Your Ref :
Our Ref : P/13/14/NMA

Section 96A of the Town & Country Planning Act 1990 (as amended)
Town and Country Planning (Development Management Procedure) (England) Order 2010 (as amended) - Article 9

Application for non-material amendment following planning application P/61/12 - Addition of solid unglazed side door & addition of small obscured glass window to south west elevation. Window and door to match other fenestration.
59 West Front Road, Pagham, ,

DATE	September 2012	DRAWN	PT
DRAWING NUMBER	12020/005	REVISION	E

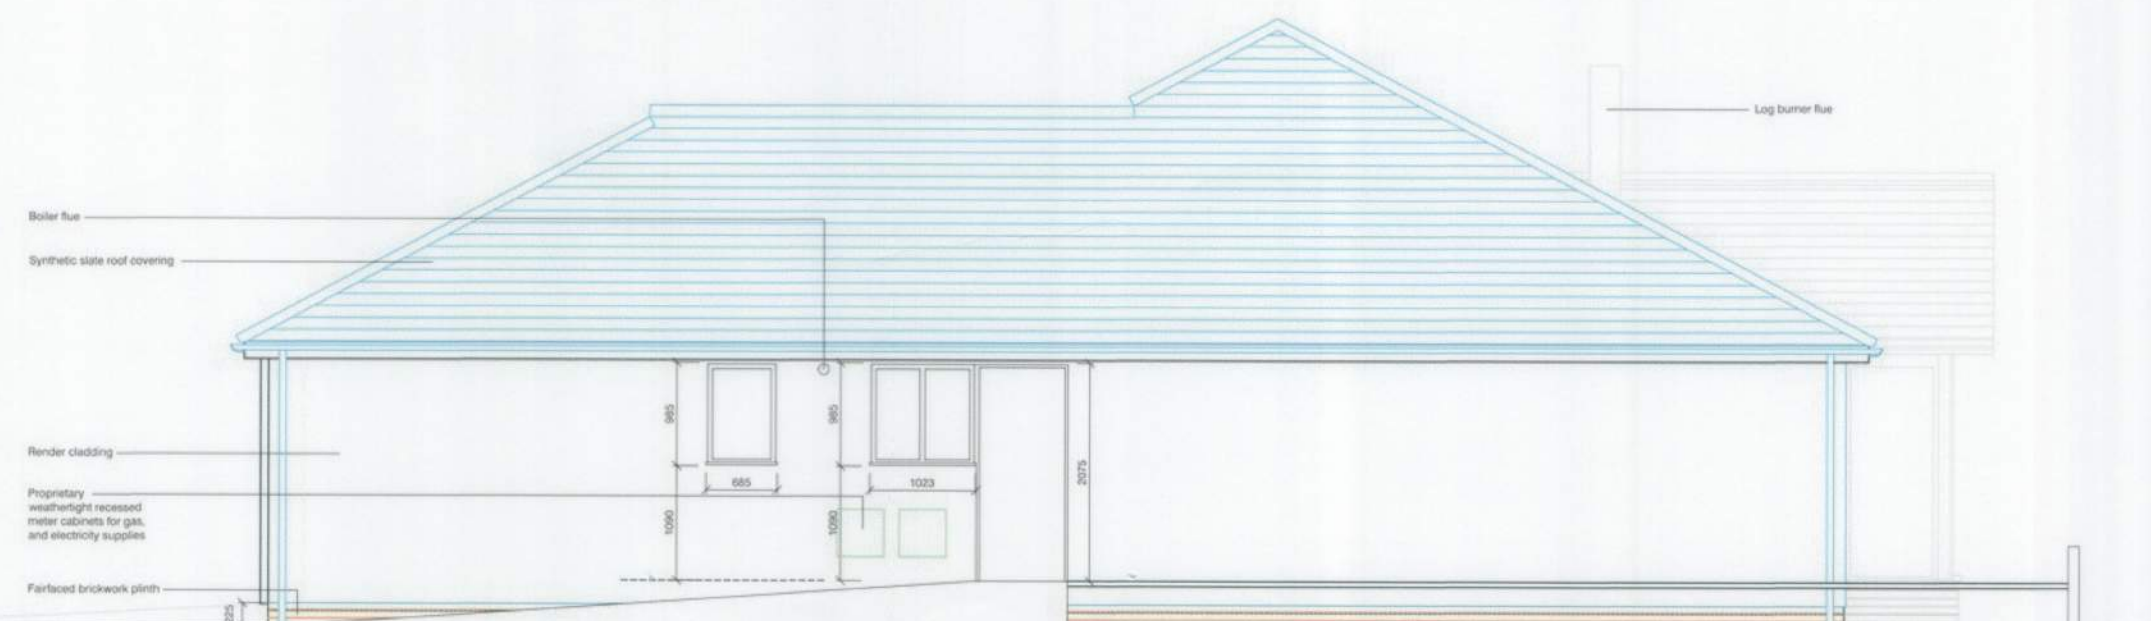
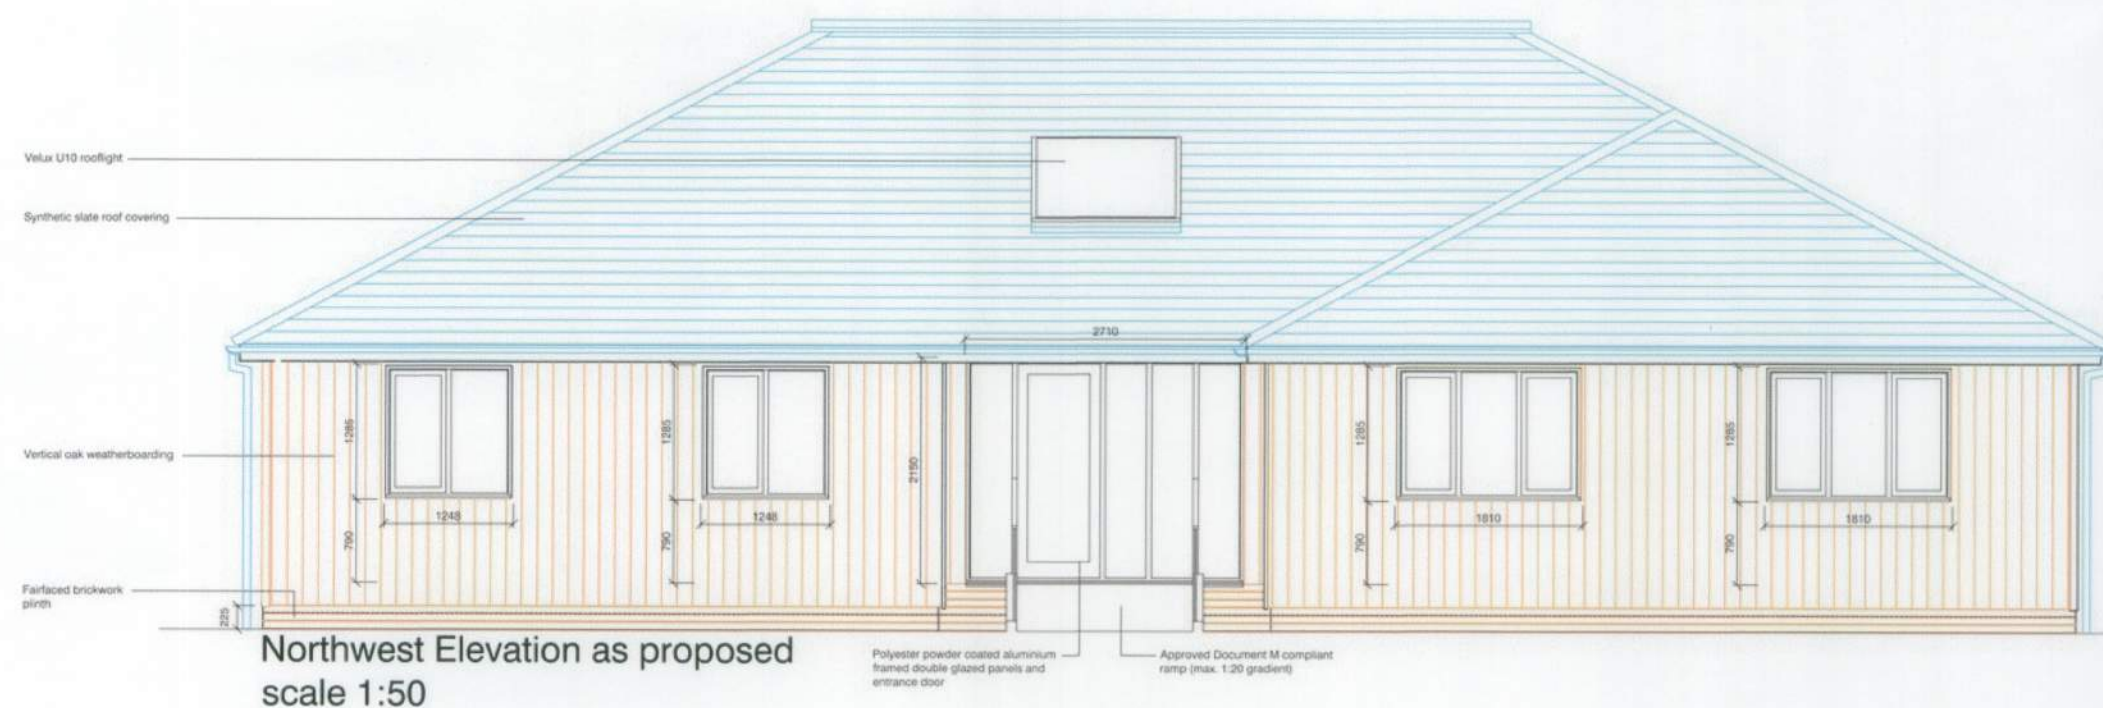
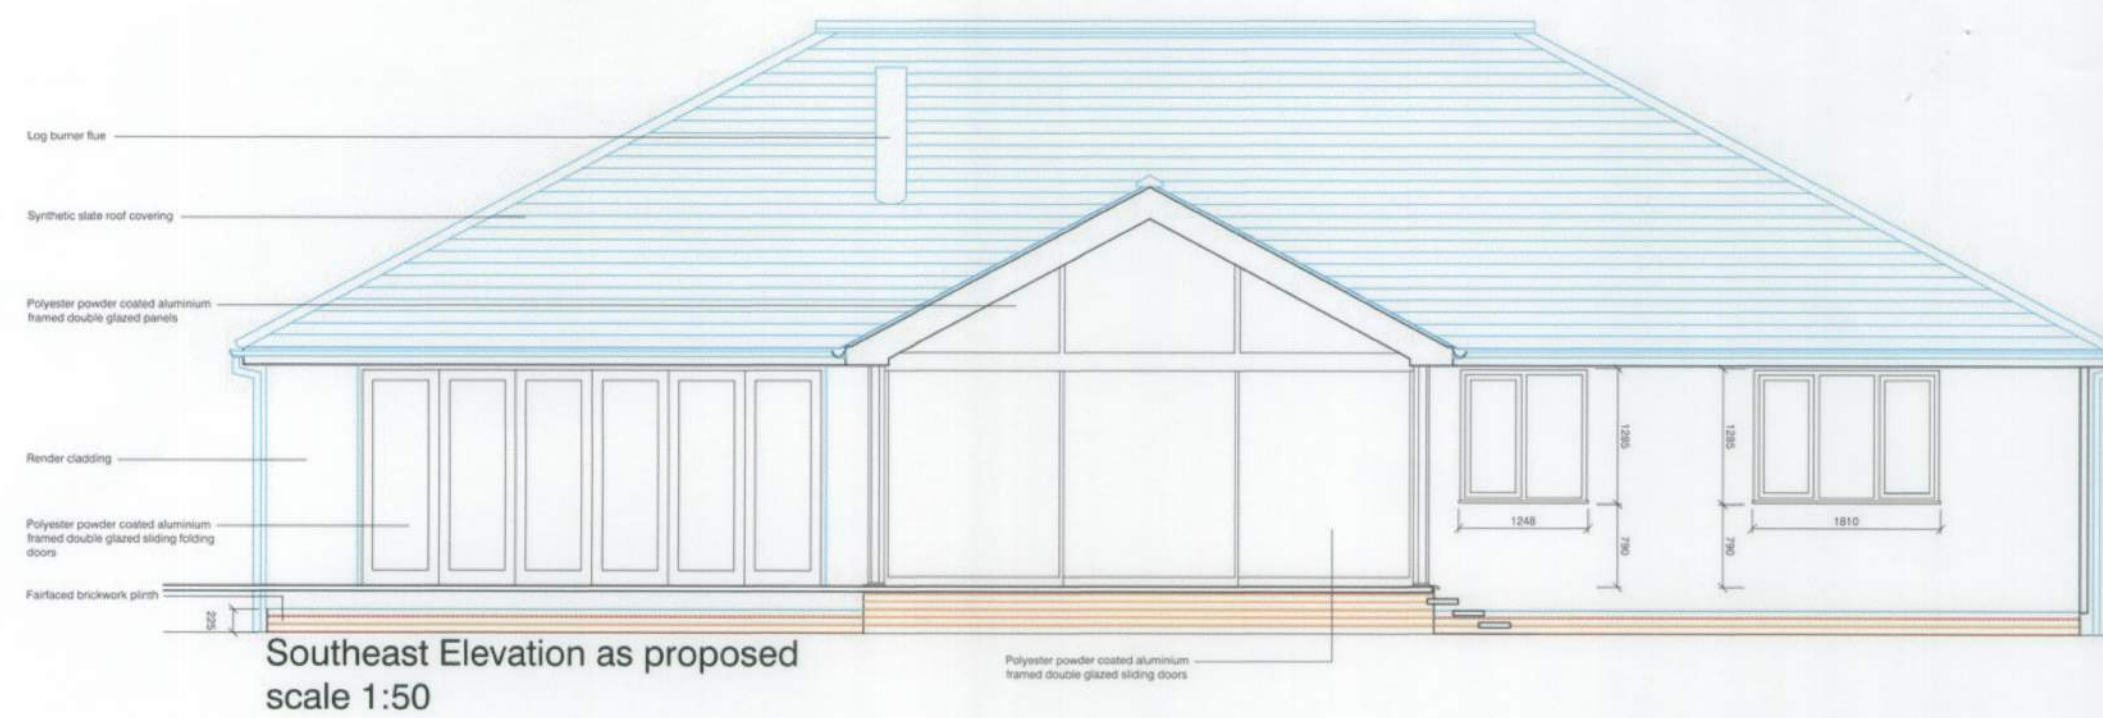
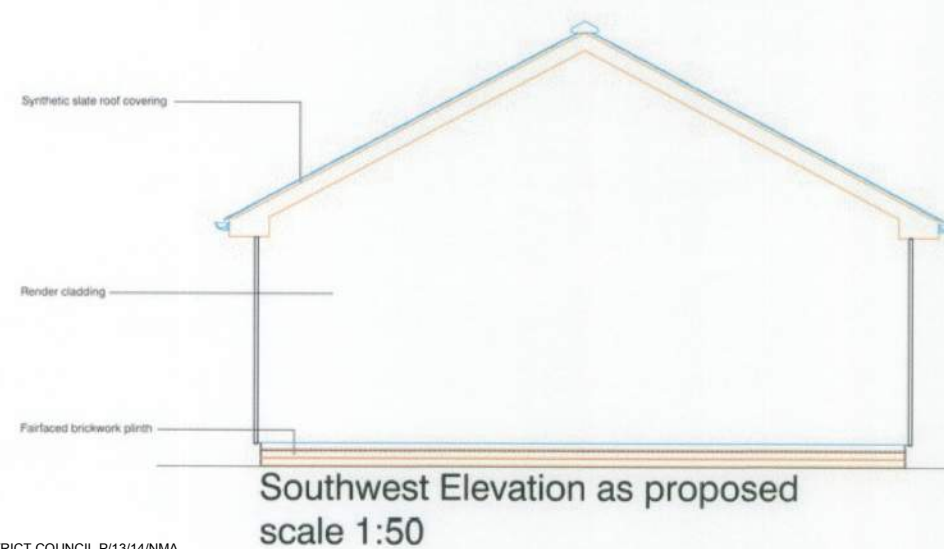
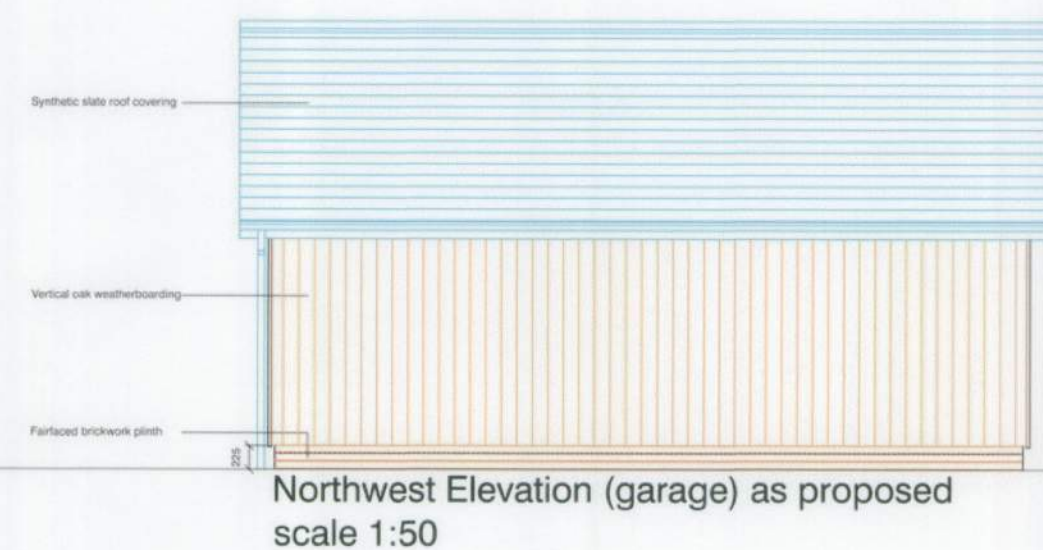
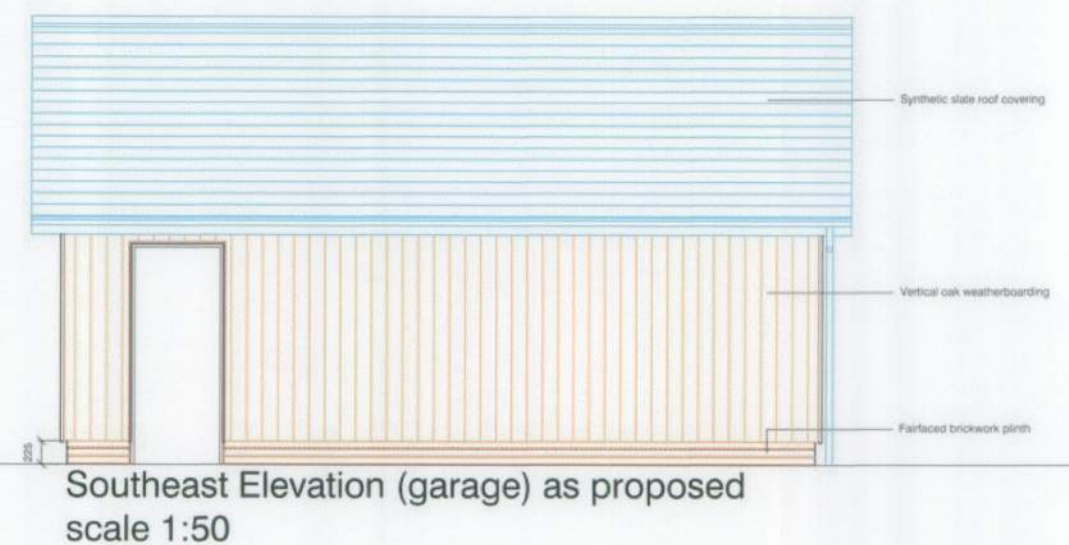
The addition of a solid unglazed door to provide external access to and from the utility room and addition of a small obscured glazed window to the south west elevation as shown on the submitted Floor Plan Drg Nos 12020/002 Rev E and Elevations Drg No 12020/005 Rev E can be accepted as a non-material amendment to the previous planning approval. The drawings now become the approved plans for planning application P/61/12.
